Application for a non-material amendment following a grant of planning permission.

PROPOSED GARAGES & BOAT SHED.
H-18-0654-10

H 18 - 0654 - 10

Proposed Boatshed and Garages, Prospect Lodge, Chestnut Terrace, Sutton Bridge, spalding.
Application number H18-0654-10

PROJECT Prospect Lodge Chestnut Terrace Sutton Bridge Spalding	
DRAWING Garages and Carports Proposed Elevations and Plan layout	
scale 1:50 @ A1	date October 10
number 08-TM-10 B

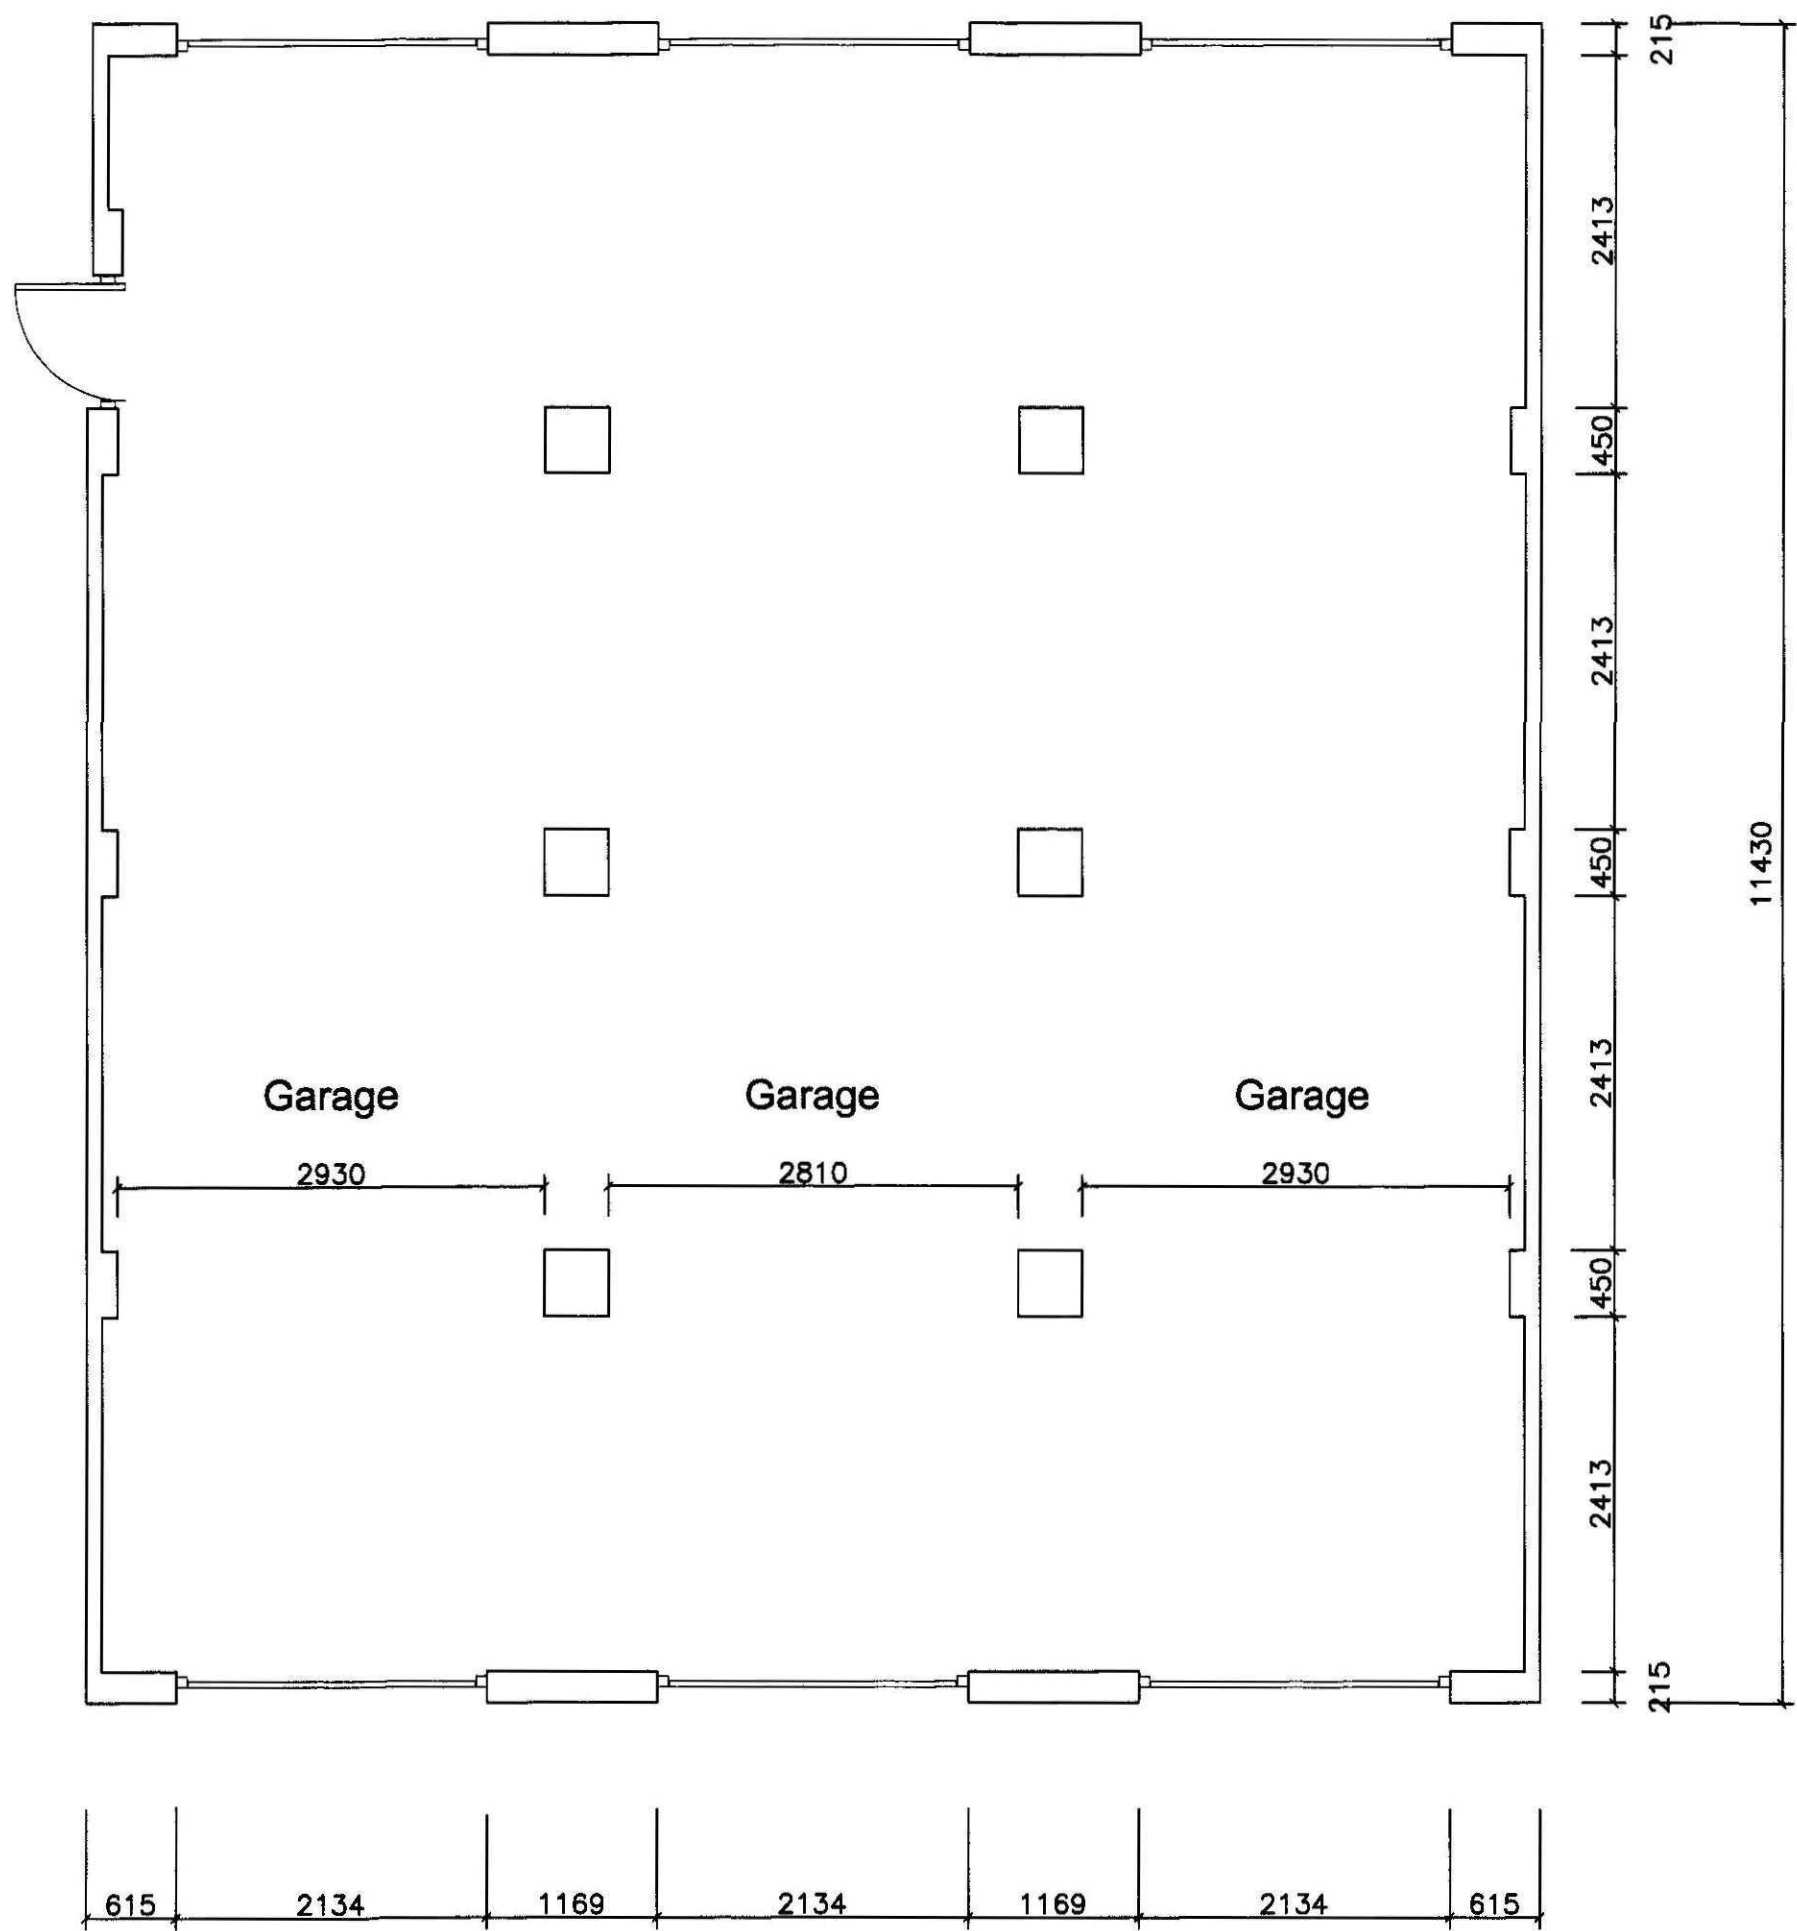
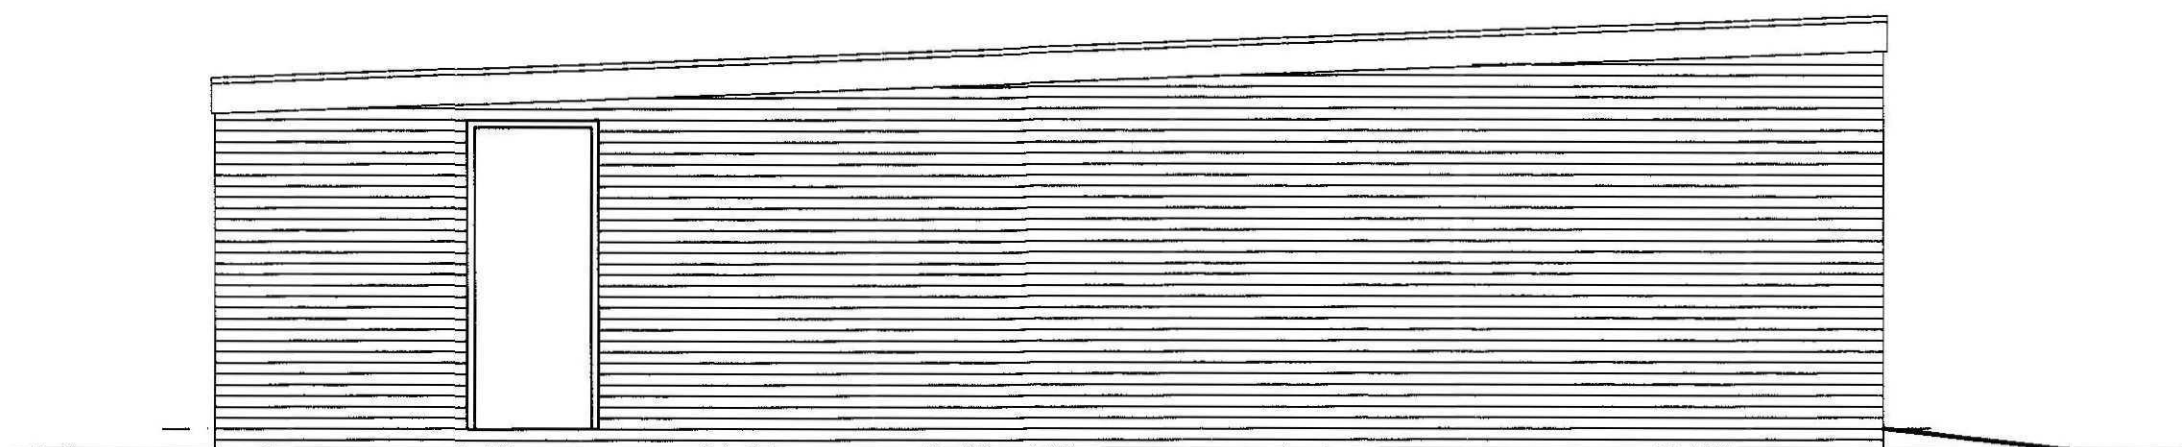
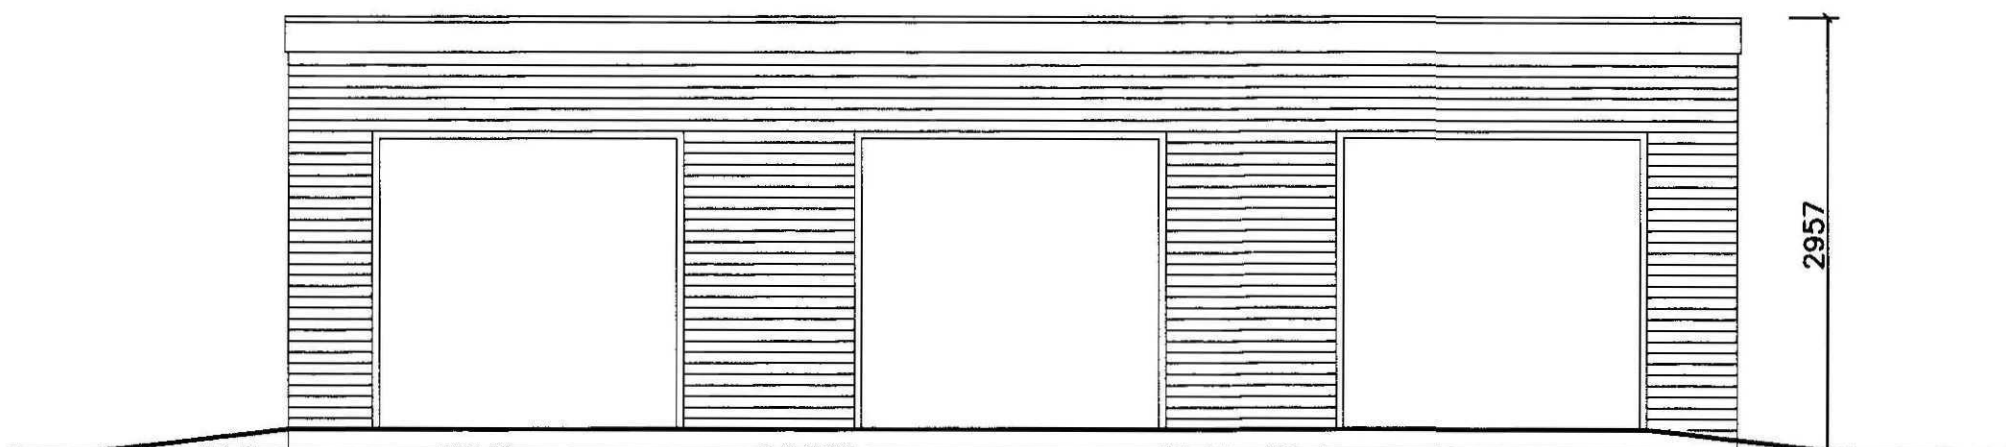
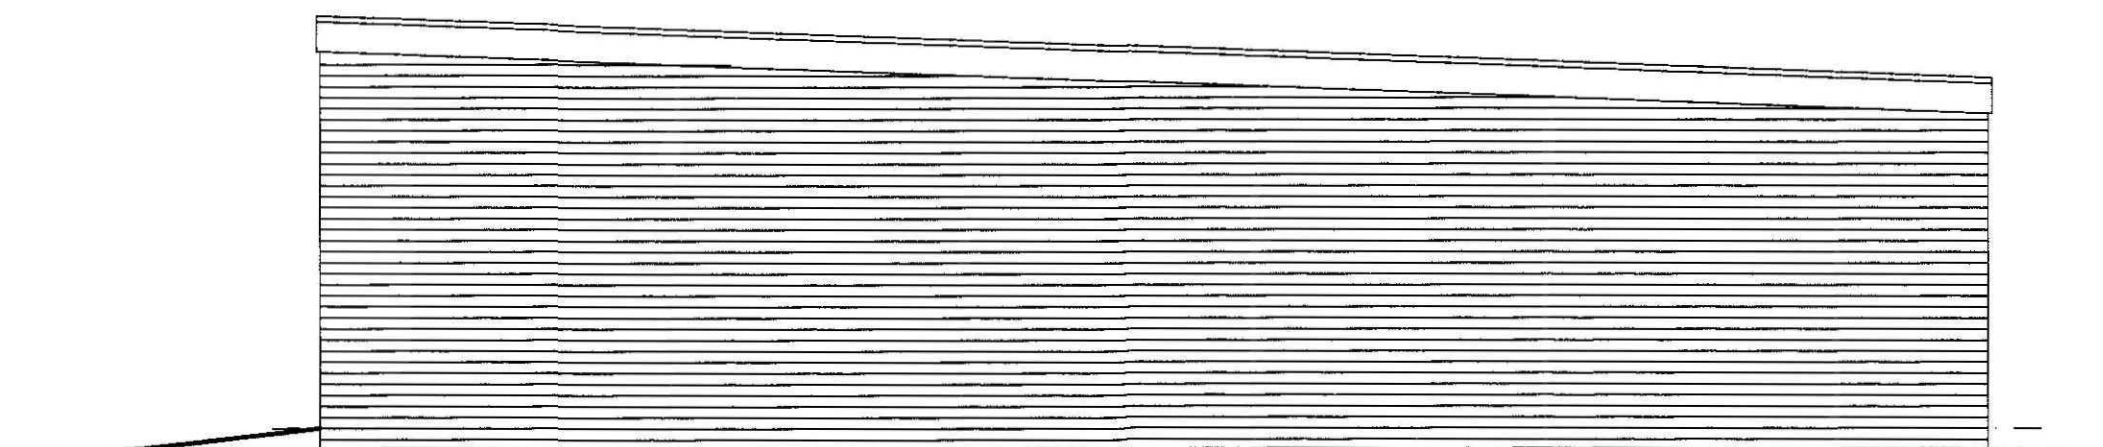
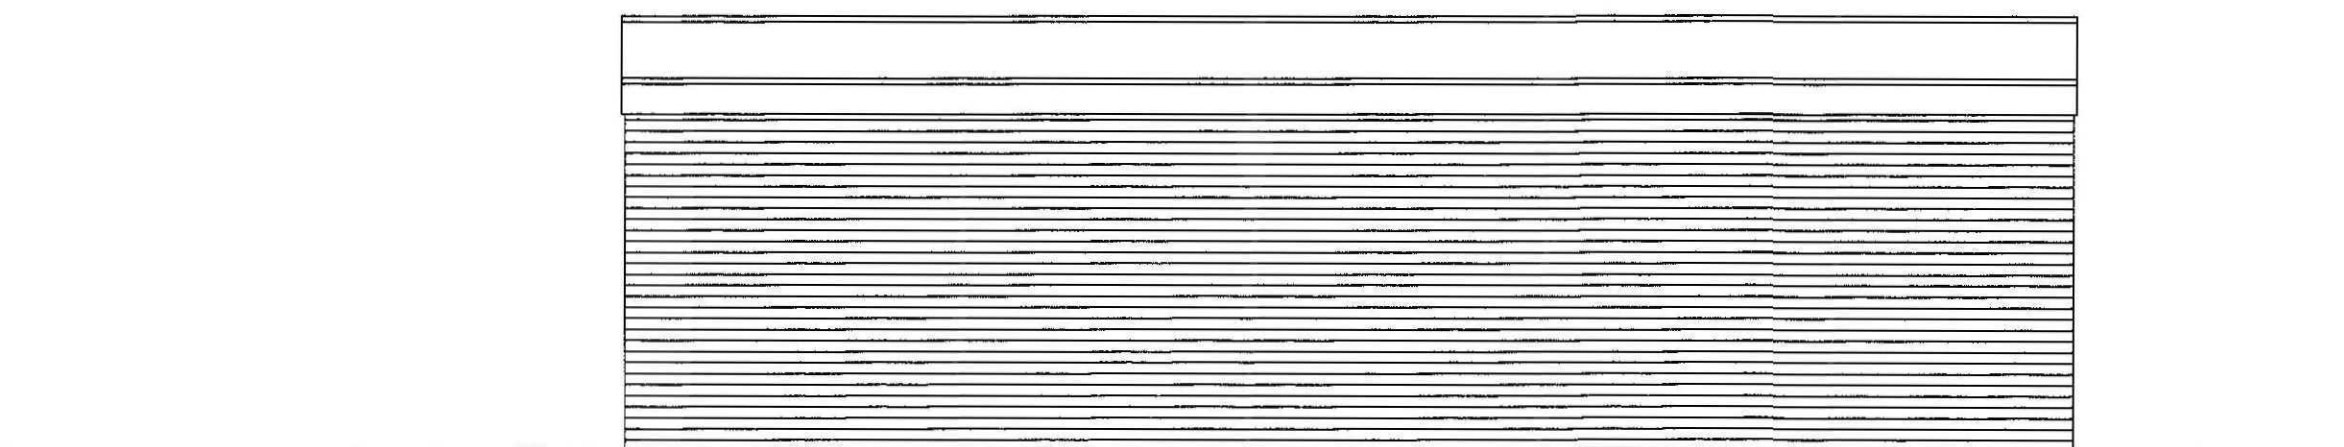
GARAGES — REDUCTION IN NUMBER + RESITING TO
ACCOMMODATE TURNING SPACE.

09-TM-10B-BOAT SHED
08-TM-10B-GARAGES.
